OXFORDSHIRE COUNTY COUNCIL'S RESPONSE TO CONSULTATION ON THE FOLLOWING DEVELOPMENT PROPOSAL

Application no: 23/02399/REM

Proposal: Reserved Matters approval for 23/01080/OUT - Details of access, appearance, landscaping, layout and scale relating to the proposed development of Class E(g)(i) (formerly B1(a)) office/commercial building and Class E(g)(ii) (formerly B1(b)) Research and Development Units, plus associated car parking

Location: Land North Of Bicester Avenue Garden Centre, Oxford Road, Bicester

PROJECT		BICESTER ARC	
TITLE			
ZONE B		SITE LAYOUT PLAN

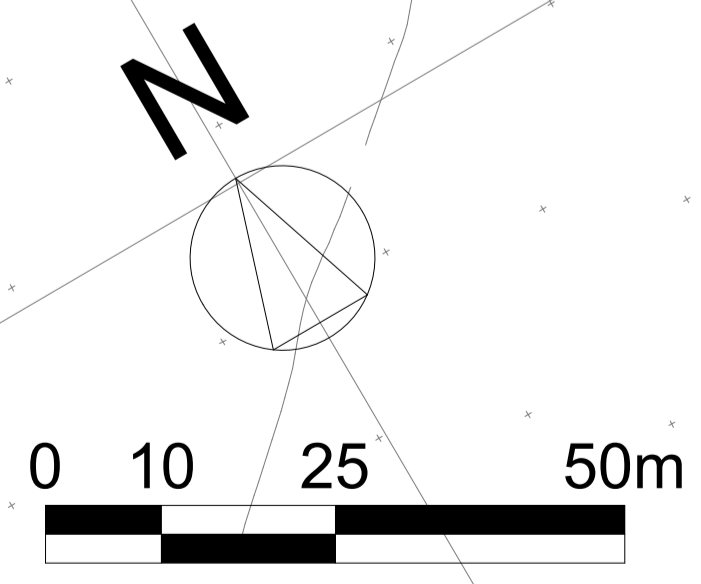
Cycle Parking - The level of provision for cycle parking spaces is noted to be immensely increased. However, I must add that the siting of the cycle parking facilities to the north of the building is not given due consideration. At present, users would need to access the cycle store by entering the shared entrance with the motor vehicles and then proceed all the way through the car park which is inconvenient and discouraging to the mode. I suggest that the parking facilities are relocated to areas close to the building entrances as I have illustrated in the snippet below (with yellow boxes).

In addition, all of the cycle parking is proposed to be double stacked which does not give regard to variations of cycle designs out there such as cargo bikes and electric bikes which are heavy and oversize for use on double stack designs. A proportion of these spaces must include sheffield stands to cater for these variations. Again, we shall require to see the design of the facilities prior to commencement of the development hereby proposed.

There is a 3m wide shared facility abutting Phase 2 parcel along Lakeview Drive which has not been appropriately connected to this development. A suitable crossing, preferably in the form of a side road entry treatment that gives priority use to active travellers is required. See snippet below.

The same issue is applicable across the service yard access further down along Lakeview Drive.

Another area that requires attention for crossing is the link between the footway along the south of the development and the R&D building.

Cycle Parking Facilities

Prior to the commencement of the development hereby permitted, details of the covered cycle parking facilities shall be provided on the site in accordance with details which shall be firstly submitted to and approved in writing by the Local Planning Authority. Thereafter, the covered cycle parking facilities shall be permanently retained and maintained for the parking of cycles in connection with the development.

Pedestrian and Cyclist means of access

No development shall commence unless and until full details of the walking and cycling connections between the development and existing infrastructure including, crossings and their positions and layout have been submitted to and approved in writing by the Local Planning Authority. The means of access shall be constructed in accordance with the approved details and shall be retained and maintained as such thereafter.
